<b>Application Ref:</b>	2025/0242			 <b>Ribble Valley Borough Council</b> <a href="http://www.ribblevalley.gov.uk">www.ribblevalley.gov.uk</a>
<b>Date Inspected:</b>	13/05/2025	<b>Site Notice:</b>	N/A	
<b>Officer:</b>	EP			
<b>DELEGATED ITEM FILE REPORT:</b>				<b>APPROVAL</b>

<b>Development Description:</b>	Proposed single-storey extension to the side and rear.
<b>Site Address/Location:</b>	31 Kenilworth Drive, Clitheroe BB7 2QN.

Client: Sandra Hogg		
Project: Proposed Alterations 31 Kenilworth Drive Clitheroe		
Dwg title: Proposed Gable Elevation		
Scale @ A4: 1:50	Date: 19.02.25	Drawn by: PD
Drawing no. 1705 - 07		Rev. -

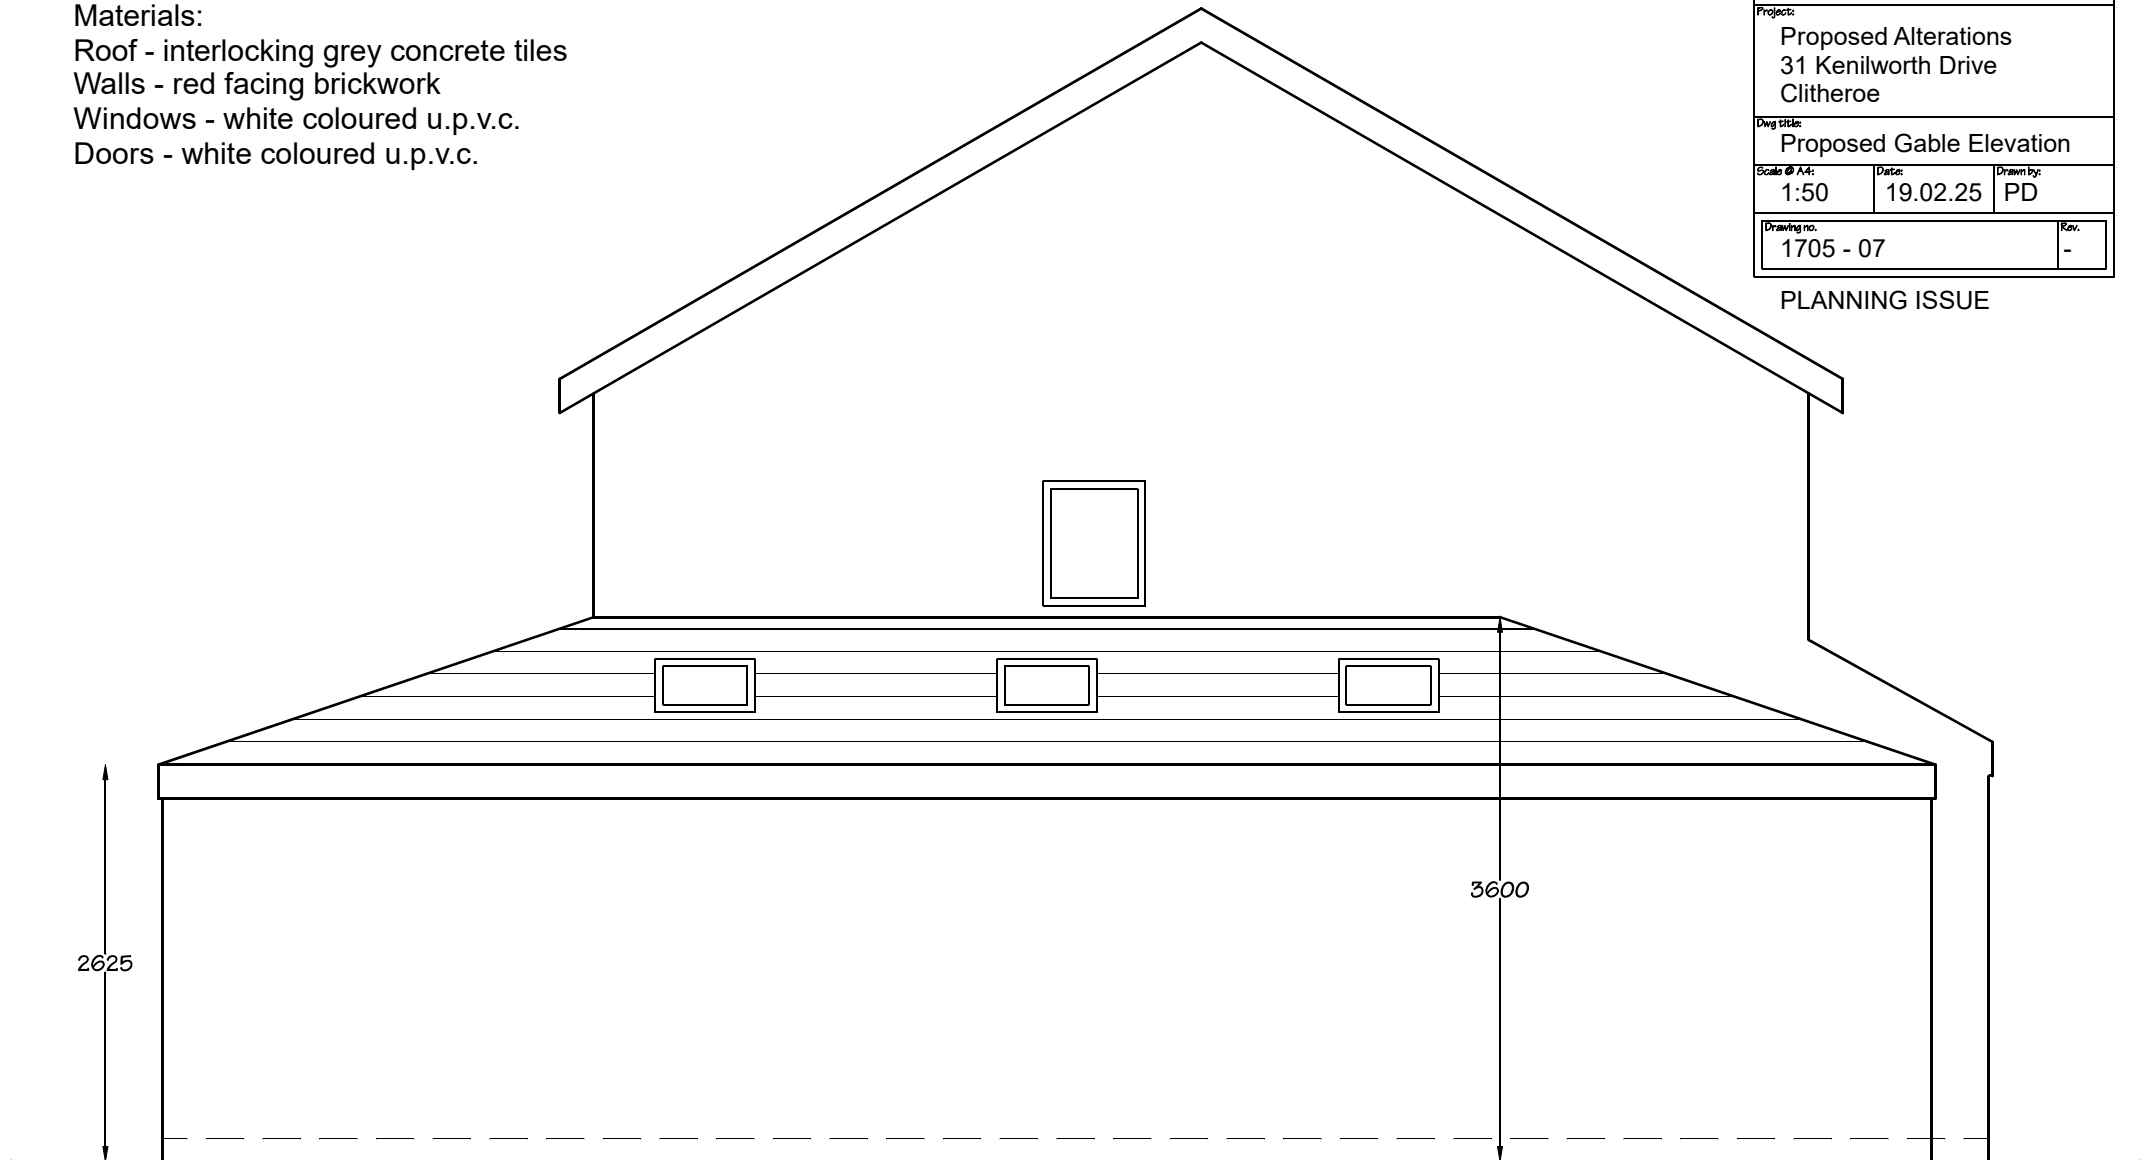
The proposed single-storey extension is to be located to the north-eastern side of the application dwelling, where the neighbouring property, No.29 Kenilworth Drive, is adjacent. The proposed extension will measure the entire length of the dwelling and rear extension, with an eaves and ridge height of 2.6m and 3.6m respectively. Given the modest nature of the extension, it is not expected that there would be an adverse impact on residential amenity in respect of loss of light or overbearing impact to habitable windows or private garden resultant of the proposal.

The proposed extension will comprise a hidden box gutter and therefore, despite the location of the extension right up to the shared boundary line, the gutter will not overhang onto neighbouring property. Whilst there are no grounds for refusal on the basis of the extension being located along the shared boundary line, this does not give the applicant the automatic right to build the extension should there be any breach of private right of access arrangements or any breach of the party wall act.

In terms of scale, the proposal is modest, measuring just 2.4m in width. The extension is set behind the existing porch extension in line with the principle building line of the property. As such, the extension will take an entirely subservient position to the host dwelling.

In regard to materials, the extension will be constructed using red facing brickwork to the elevations, grey concrete roof tiles and white uPVC windows and doors. This is consistent with the application dwelling and properties in the surrounding area. In addition, similar development was observed in the area, on

Client: Sandra Hogg		
Project: Proposed Alterations 31 Kenilworth Drive Clitheroe		
Dwg title: Proposed Site Plan		
Scale @ A4: 1:200	Date: 20.03.25	Drawn by: PD
Drawing no. 1705 - 102	Rev. -

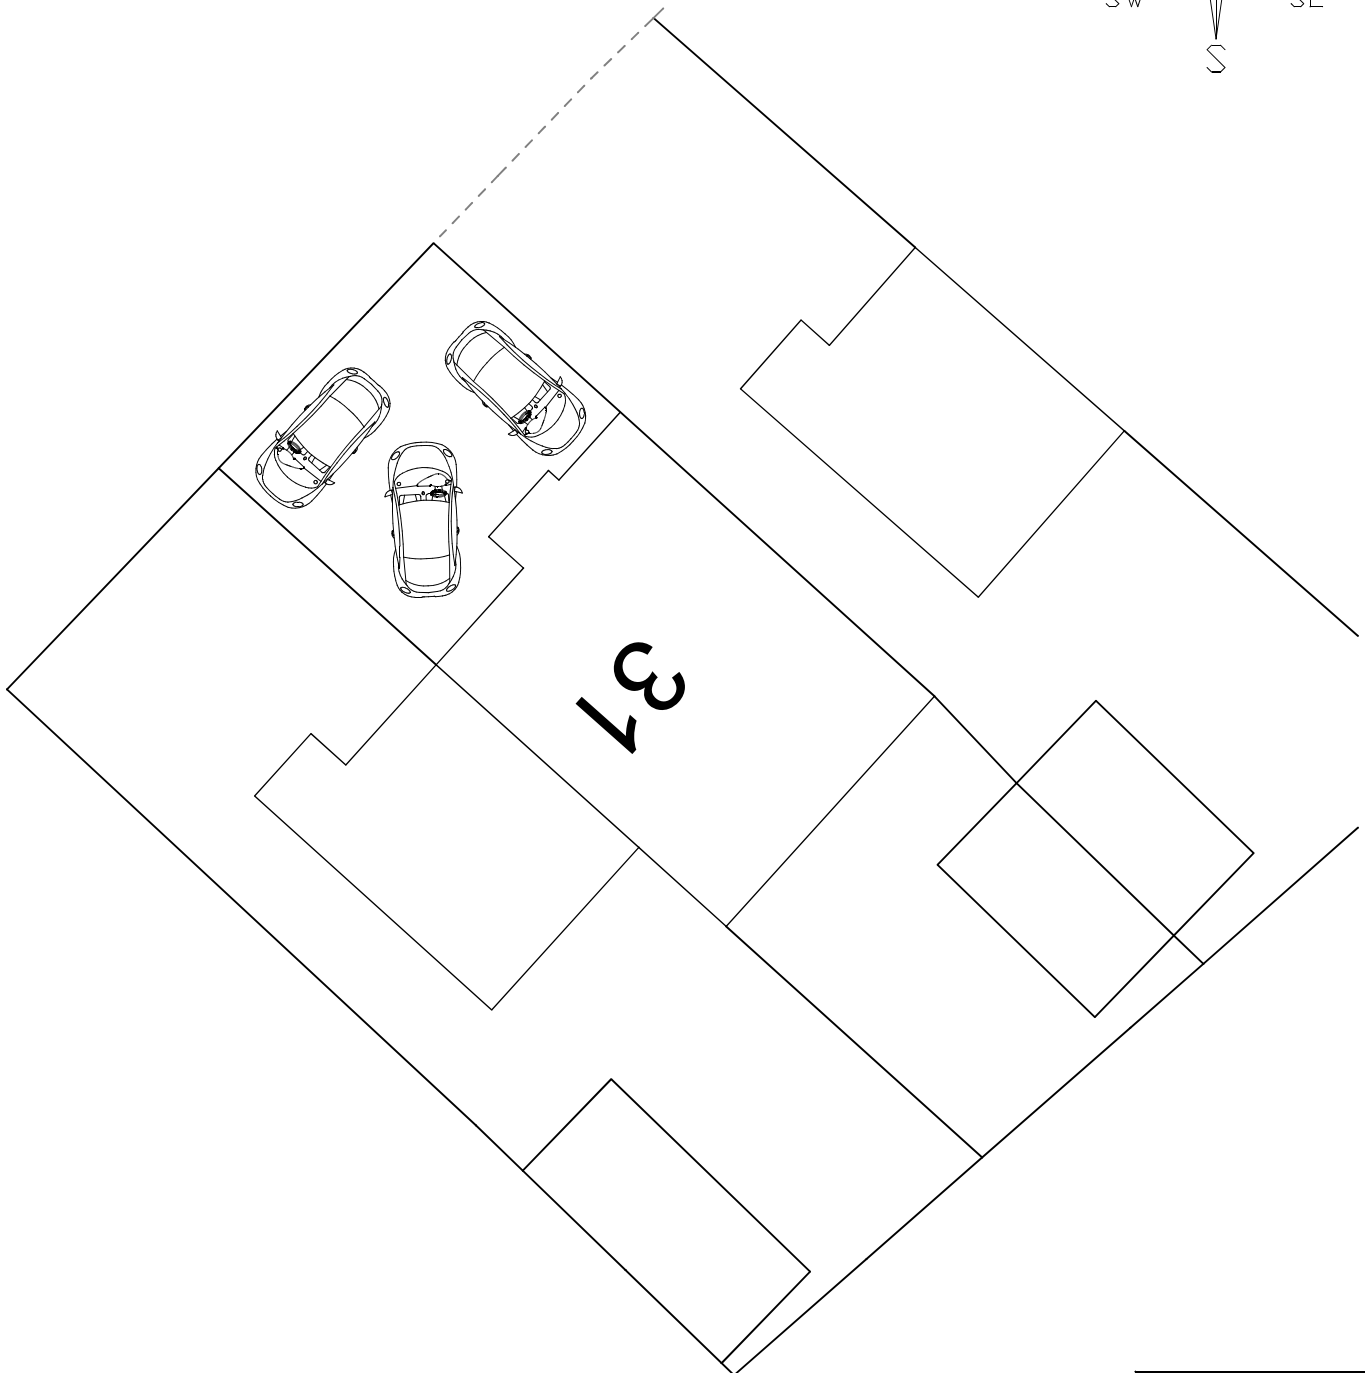
It is noted that letters of representation raised concerns over the detail within the application form and the parking arrangements. It has been demonstrated that there are 3 parking spaces at the front of the site and that these will be retained. Given the parking provided complies with parking standards for a 5 bedoomed dwelling, there are no grounds for refusal on this basis. LCC Highways have not raised any concerns on highway amenity grounds in respect to limited access to the neighbouring garage. Matters relating to rights of access are private civil matters and not grounds for refusal in planning terms.

It was observed on site that the highway works to amend the driveway/access have already taken place and are in use, as per the existing plans. The lamppost has already been removed. The above comments are therefore outdated and not considered relevant to the application.
